Our Ref: PREAPP/21/00166

**PLANNING REFERENCE:** PREAPP/21/00166

**PROPOSAL:** Proposed repair, restoration, alterations of existing barns to provide recreational facilities.

**LOCATION:** Aston Hall, Aston Munslow, Craven Arms, Shropshire, SY7 9ER.

PROPOSED POOL BARN
 SECTION A-A
 SOUTH EAST ELEVATION

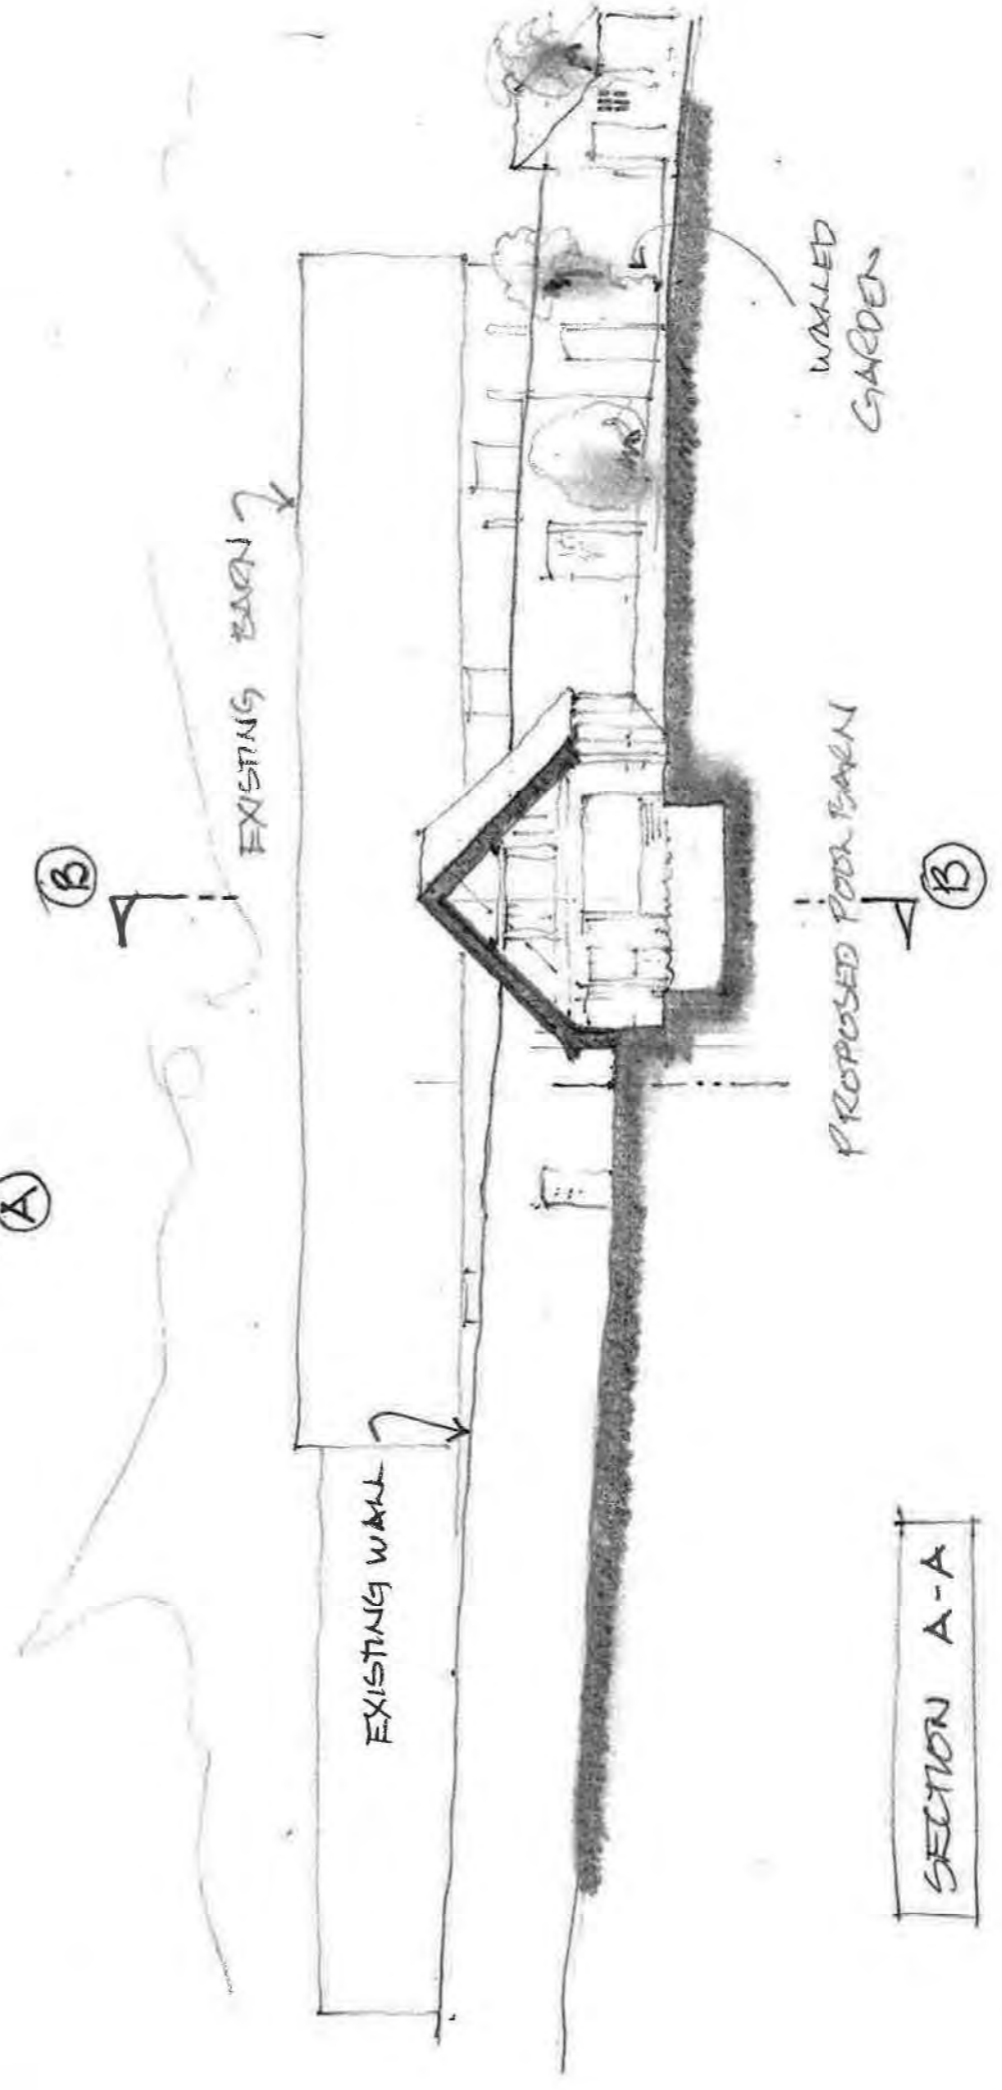
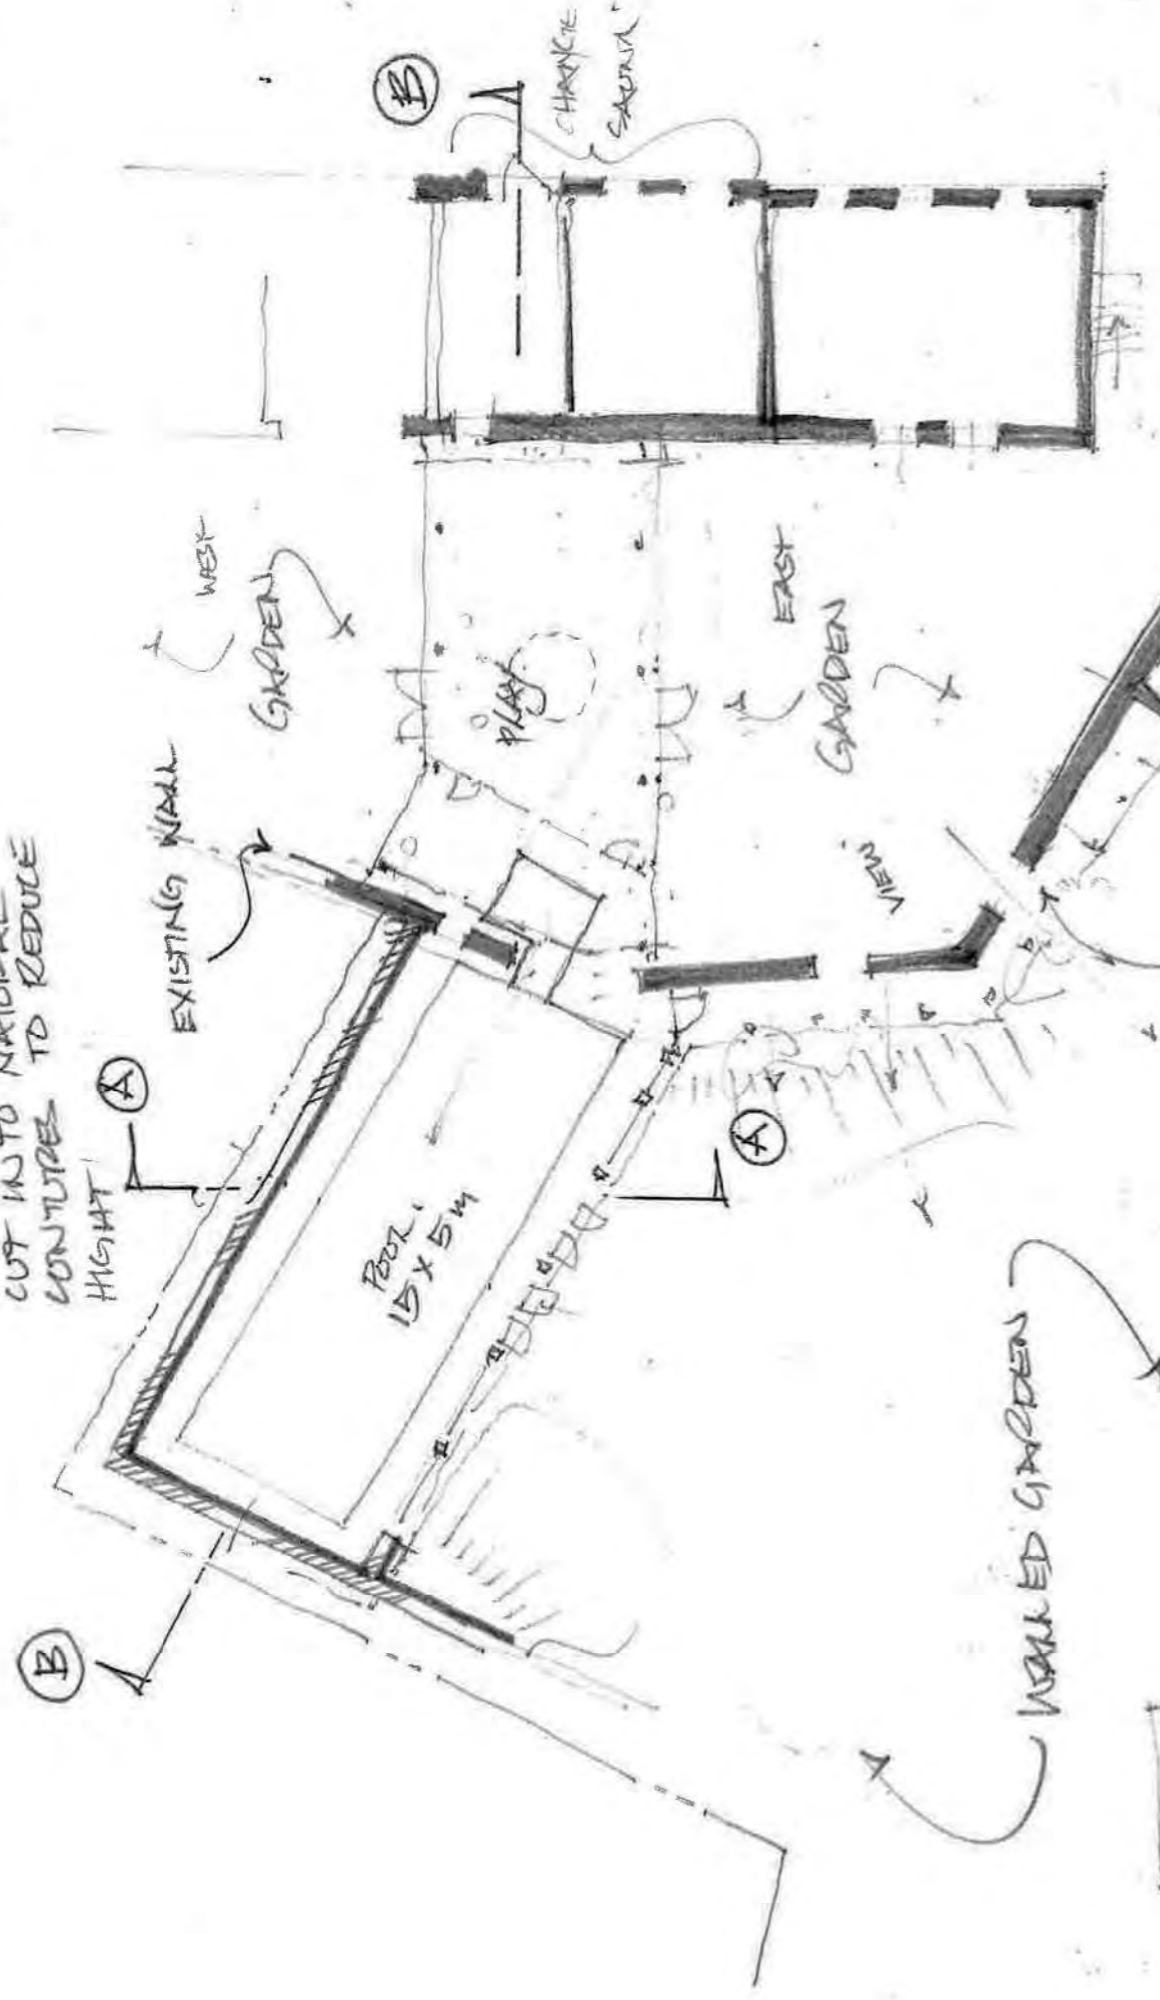
with her assessment in terms of details. There is no objection to the installation of an internal pool, and physical intervention may be extensive in any event due to the need to remedy structural issues. I am unclear how the “corner tower” platform above the pool, facing the yard would be designed, constructed and supported but this is an area that raises significant concern, for reasons of appearing dominant and incongruous in the agricultural setting. Similarly, the glazed colonnade has the potential to detract from the simple and functional elevations of the buildings facing into the yard, though I accept they may deliver some structural support for the main building. There is no objection to the use of the yard area for domestic space. However domestic structures and additional clutter should be kept to a minimum in order to maintain the open functional aspect of the yard.

# Appendix 12.5a: Proposed driveways plan

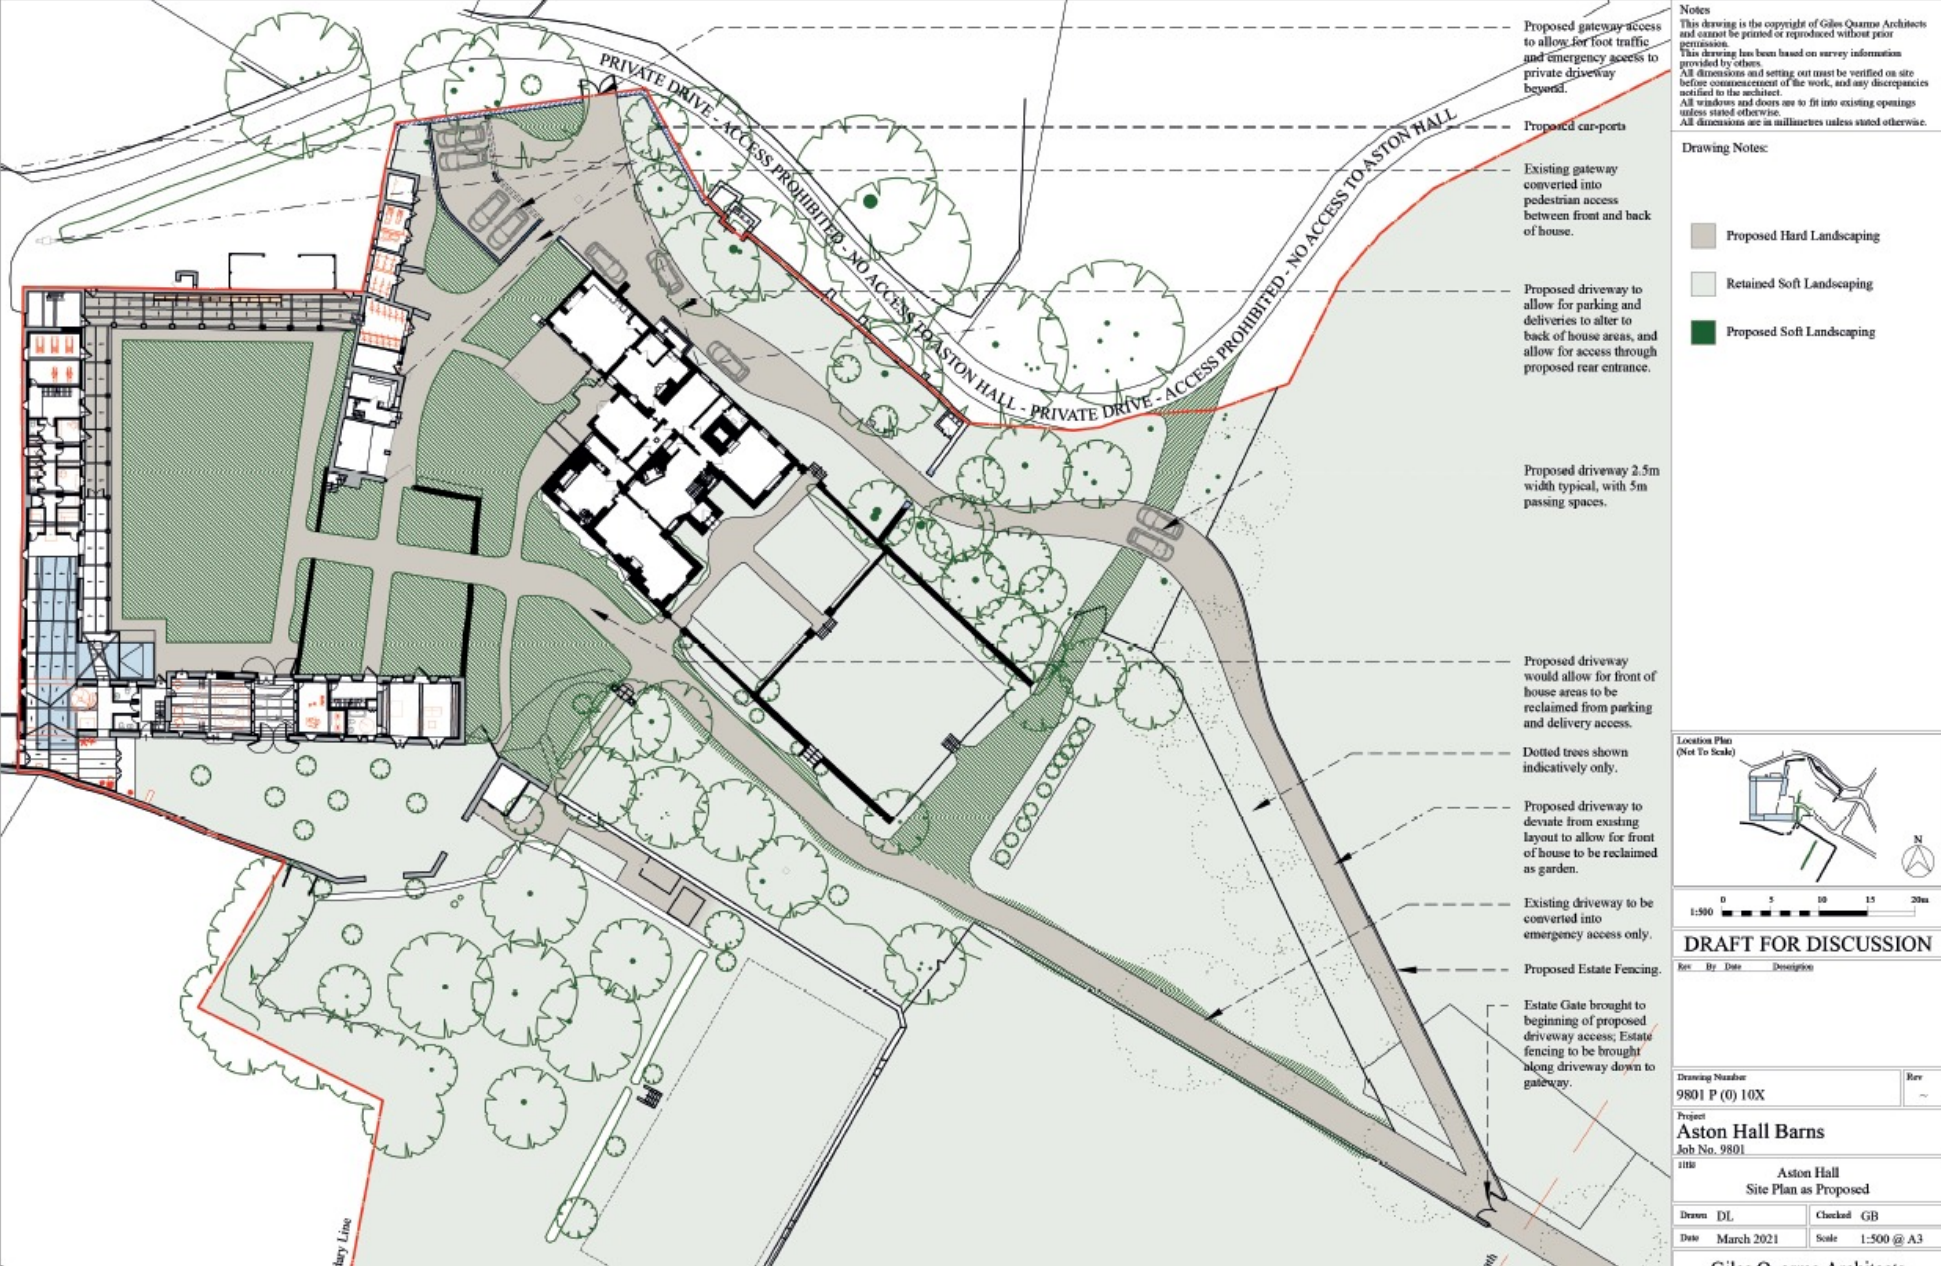
The alternative route leading off the access avenue would be a significant operation involving substantial ground works, re-modelling of existing boundary walls, and likely the loss or harm to significant trees/hedges. At the very least this part of the proposal should be assessed in an HIA and supported by an arboricultural assessment. Notwithstanding, I have significant concerns that these works may lead to unacceptable harm to the curtilage fabric of the listed building, and harm to its character and setting, to which existing trees contribute. In any event, the parking space as illustrated appears only large enough for a few cars, which during transit are unlikely to disrupt the amenity of occupiers of the Hall. Essentially the additional harm appears disproportionately large to the level of amenity gain, taking account all works are limited to ancillary domestic purposes.

# Appendix 12.5b: Proposed renewable energy installations

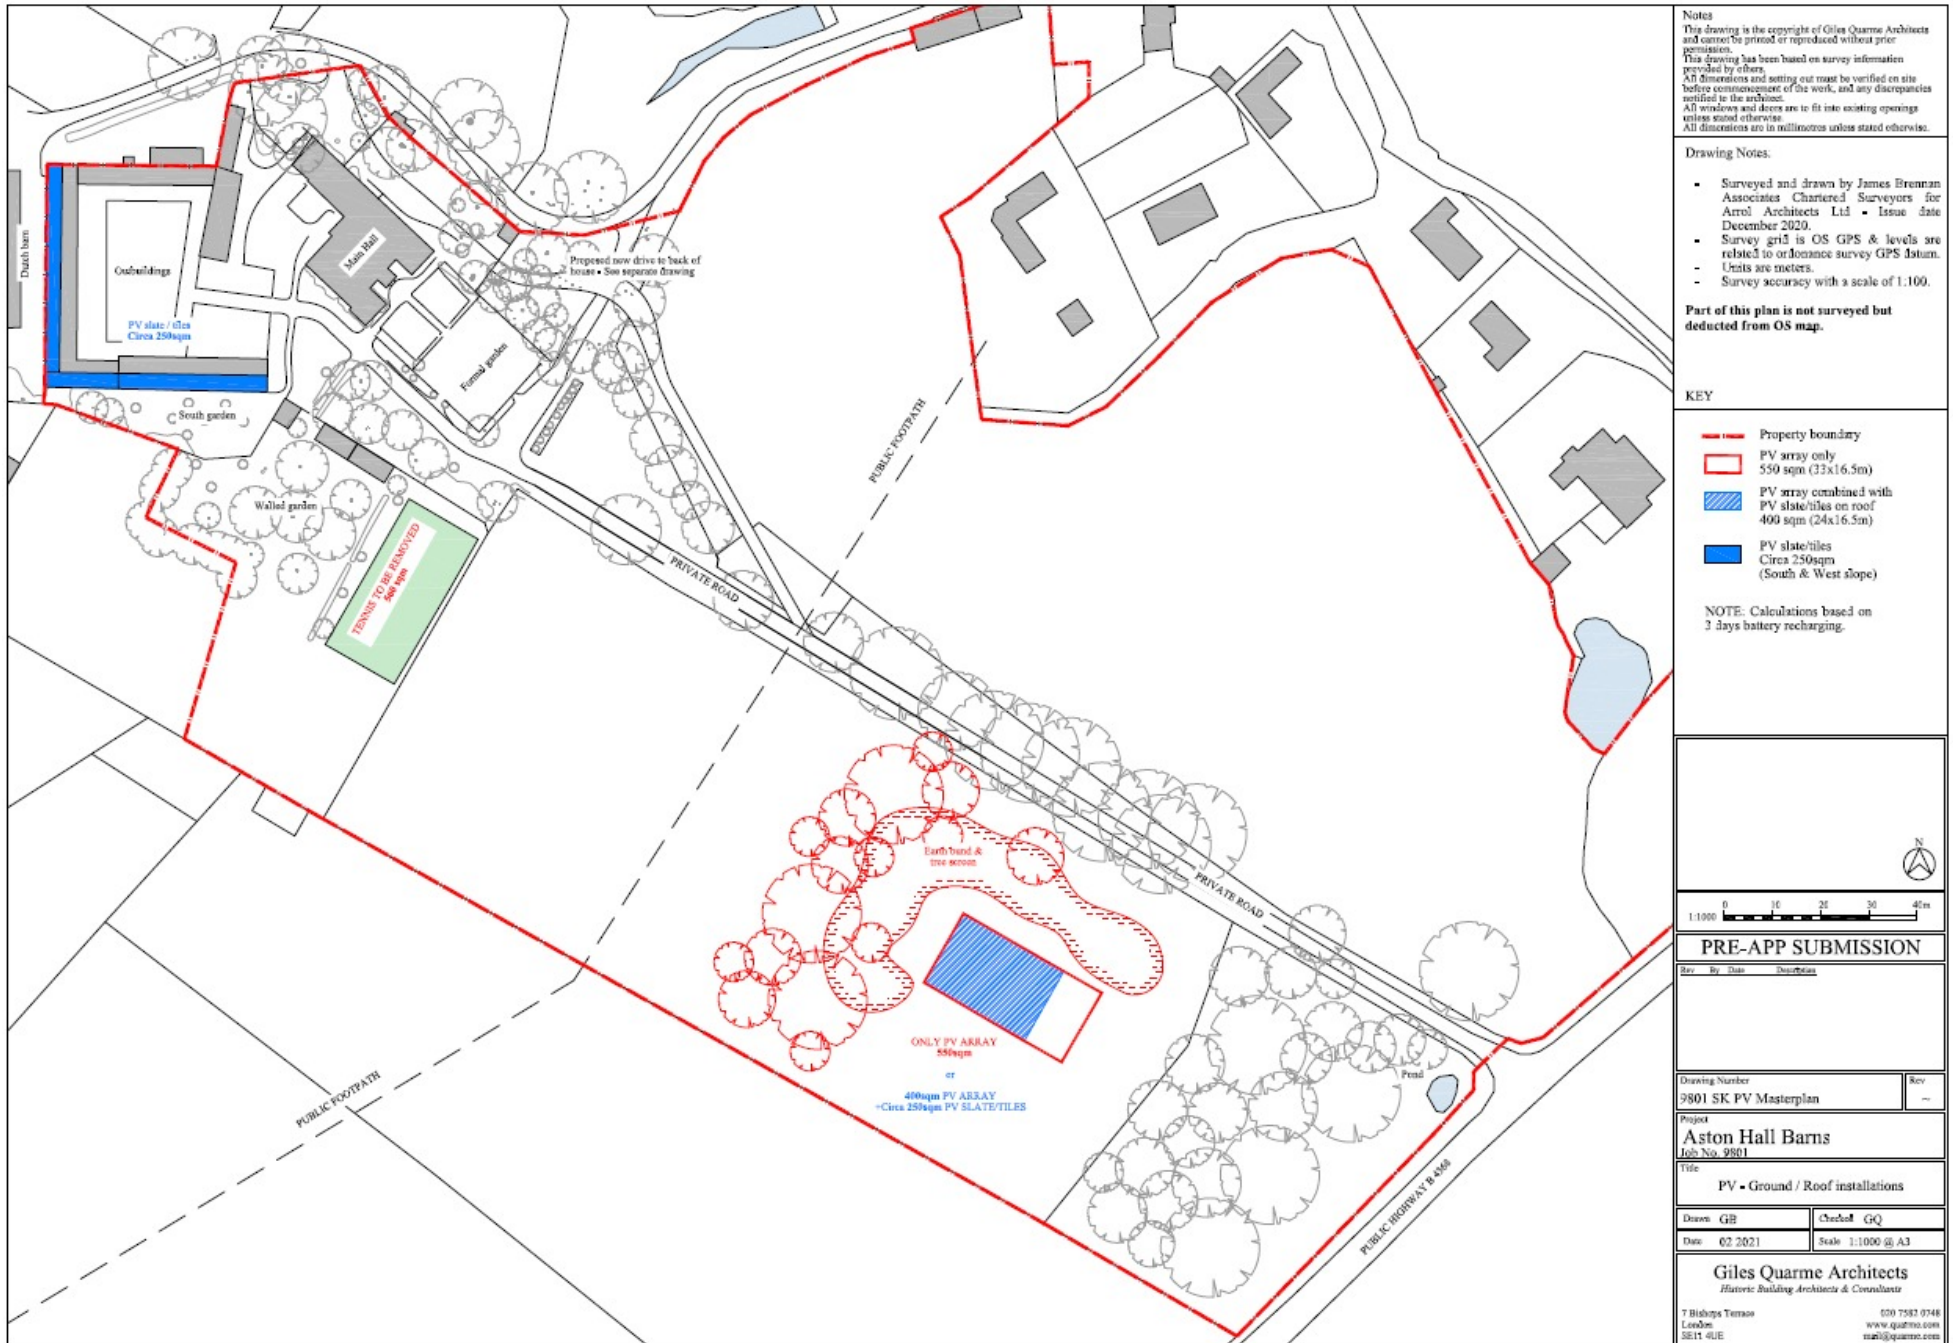
Where photovoltaic cells are to be installed on the roof, they should be limited to the rear roof pitch and a consistent roofing material should be used throughout, rather than slate on the rear and tiles on the front. There is no objection to the GSHP installation though associated infrastructure should as far as possible, make use of existing space within buildings, rather new outside buildings. The proposed solar array should form part of a detailed Historic Impact Assessment (HIA). Where new structures are necessary, they should be discreetly positioned and/or appropriately screened by landscaping.
